**WEST SUSSEX COUNTY COUNCIL
PLANNING SERVICES CONSULTATION**

SUBJECT: LU/17/162 - Demolition of existing building, erection of 10 residential dwellings (Use Class C3) with associated open space, landscaping, parking, and access. Departure from the Development Plan.

LOCATION: Land North & West of Toddington Farm Cottages, Toddington Lane, Wick, Littlehampton, West Sussex, BN17 7PP.

This is the second WSCC highways and transport response to the above application. It follows review of a Stage 1 Road Safety Audit provided by the applicant (see RKS Associates Ref. No. VRP899-01 – issue date 21st August 2017).

Figure 3. Proposed site plan with the site boundary shown in red.

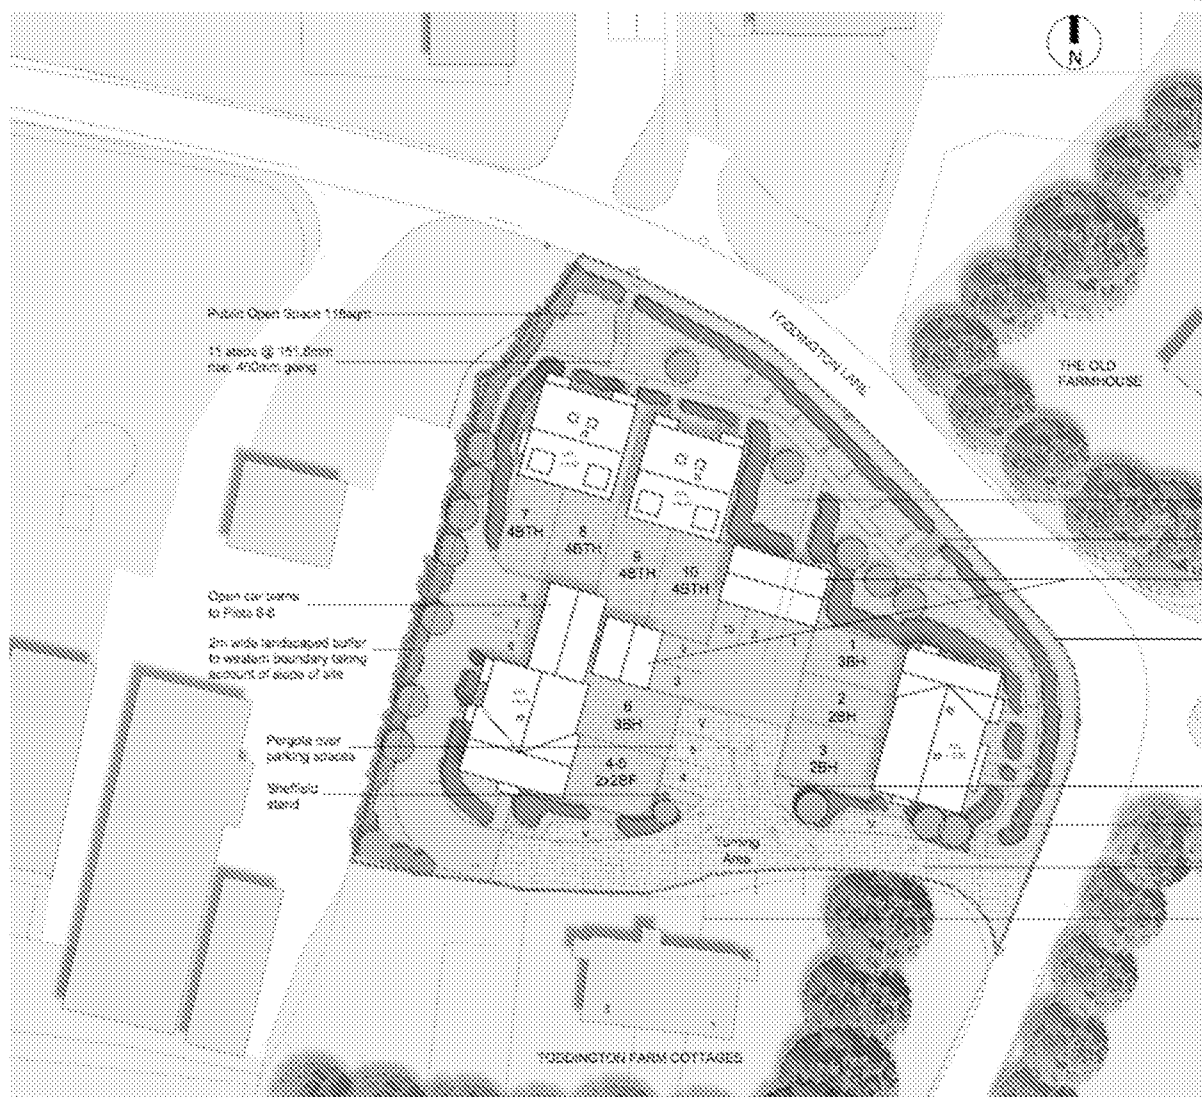
The proposed development layout is shown on drawing title "Site Layout Proposed" No. 6436 (00) 002 Revision 'D' produced by ECE Architecture. The first section of access road is shown as a 'shared surface' intended for joint-use by vehicles and pedestrians sans footways. Although a footway is shown running to the north of the access, terminating where it meets the revised junction, it introduces pedestrians into the path of vehicles emerging from the site where visibility does not appear to be provided. Furthermore, there is no demarcation of where the access road becomes shared surface – this needs to be shown. This should be amended to bring the footway into the access road with a change in surfacing from traditional access road to shared surface just past the bellmouth (basically, the shared surface shown in blockwork should be constructed shown raised above the level of the blacktop to be provided in the initial part of the bellmouth). A demarcation line should also be shown highlighting the extent of public highway where it meets private land. Finally, visibility at the point pedestrians emerge to the access road should be shown. Blockwork should only be shown west of the appropriate demarcation line indicating where the shared surface starts.

Scrutiny of the plan showing access where it joins Toddington Lane reveals that visibility splays have not been shown. These should be provided in accordance with guidance contained in

Manual for Streets. A 2.4m 'x'/minor road distance would be suitable on this occasion for the number of dwellings proposed. Based on a 30mph speed limit on this section of Toddington Lane, this will necessitate re-locating plots 1-3 as they would obstruct the 'y'/major road distance of 43m in the trailing traffic direction (looking north from the access road). A visibility splay should also be provided in the leading traffic direction looking south from the entrance. Any vegetation or landscaping in advance of the splays should also be carefully considered to prevent obstruction of said visibility splays. Anything other than grass would need to be considered by way of a 'licence to plant' if shown on land forming part of the public highway which would need to be discussed with the Local Highway Manager at WSCC. Pedestrian visibility splays should also be shown either side of any pedestrian access points.

A footway is shown running northwards from the access point, terminating at the western end of the site adjacent the former Hollyacres Nursery site. The currently scales at 1.5m wide – it should be 2.0m wide. Also, any path should be shown connecting to the existing footway currently terminating where Phase 1 of the Hollyacres site has been built. If the applicants intend to construct and occupy their site in advance of Hollyacres Phase 2 being built, then they will need to provide a suitable footway connection westwards from their site connecting to the one already built. A plan showing how they will be able to provide such a footway is required.

With regard to the configuration of the houses within the scheme, seven of these are shown fronting Toddington Lane. Given that the parking for these properties is shown behind them and given that on occasion, some residents tend not to favour this arrangement, possibly leading to parking on the highway, it is recommended the layout be re-configured to show the majority of houses facing inwards with parking to the front of them. This is particularly important given that the site is on a bend in Toddington Lane where on-street parking should be discouraged as far as is practicable for road safety reasons. It may be that the LPA would wish for some frontage development so early discussion with the planning case officer and, indeed, the CHA should be undertaken. If some housing is retained facing the road, careful design of car parking for those properties should be given. Also see comments below about parking.

Steps down to Toddington Lane – These should be removed and replaced with a suitably dimensioned and gradient ramp to suit all users. Visibility should be provided where this path emerges to the back of the footway running around the boundary of the site and consideration given to a possible safety barrier that might be required.

As documented above, the location of some of the parking spaces could lead to indiscriminate parking on the public highway on a bend in the alignment of Toddington Lane and possibly close to the railway crossing. Also, the parking spaces dimensions are too short (they should be 2.4m wide by 4.8m long – slightly wider where they immediately adjoin buildings/walls etc.). Also, it cannot be determined how large the car barns are. Manual for Streets recommends 3m wide by 6m long. Visitor parking is lacking in certain parts of the layout (particularly for plots 4-10). This should be looked-at again. The applicant should also set-out how parking numbers have been established. The WSCC Parking Calculator should be used. Finally, parking and access arrangements for Toddington Farm cottages need to be shown alongside that for the new development to see if both work alongside one-another.
